From: ENVU Biodiversity and Land Use
Sent: 21 January 2026 09:16
To: Planning ContactCentre
Subject: 2025/91903 at location Land adjacent, 837, Manchester Road, Linthwaite, Huddersfield, HD7 5NF

Please see ecological commentary below:

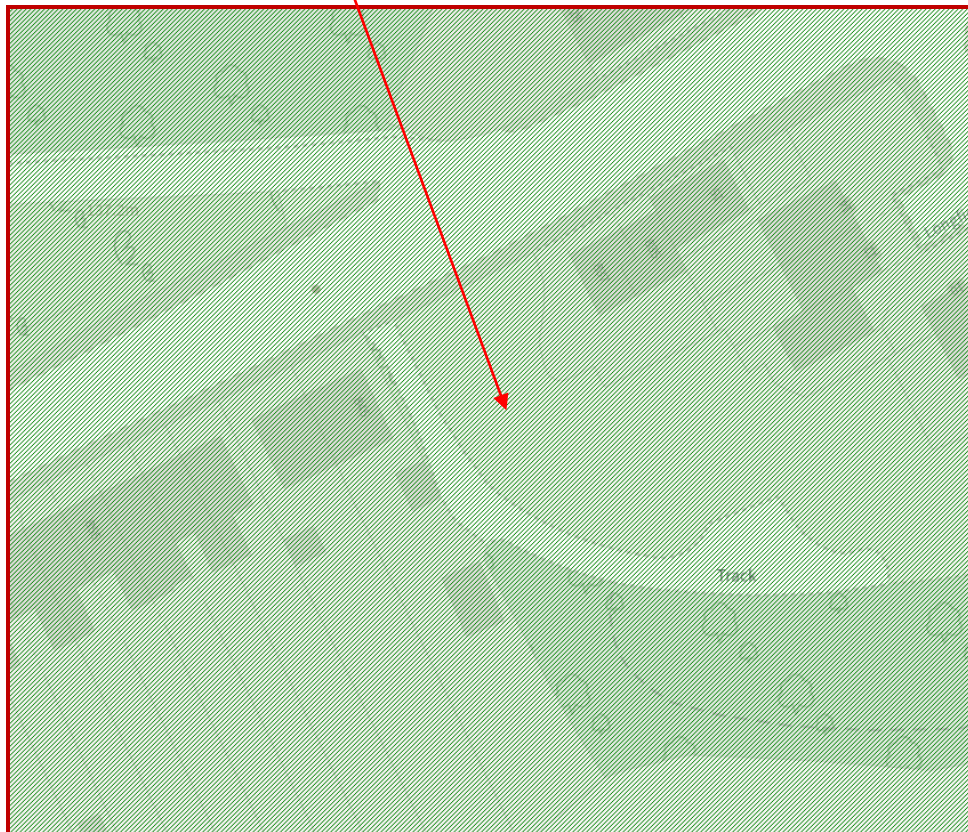
The Preliminary Ecological Appraisal and Bat Scoping Report (JCA, April 2025) is reasonable and acceptable. Bluebells were observed within trees T08-T12. It is recommended that these trees be retained. A tree protection conditions will be added. The applicant currently does not have permission to remove these trees as bluebells are partially protected under WCA Schedule 8. Currently, from the Design and Access Statement (AK Planning, July 2025) the proposed stone flags and tarmac area for car parking is to replace the areas of trees where the bluebells are. It is recommended that the plans are reviewed to ensure no disruption to the trees occur.

It is recommended that post development calcs are reviewed as currently the applicant does not have permission from Kirklees Council to remove trees T08-T12 as WCA partially protected bluebells have been observed in that area. The current post development plans are not accepted.

TBC once post development plans are reviewed to protect the trees and bluebells onsite.
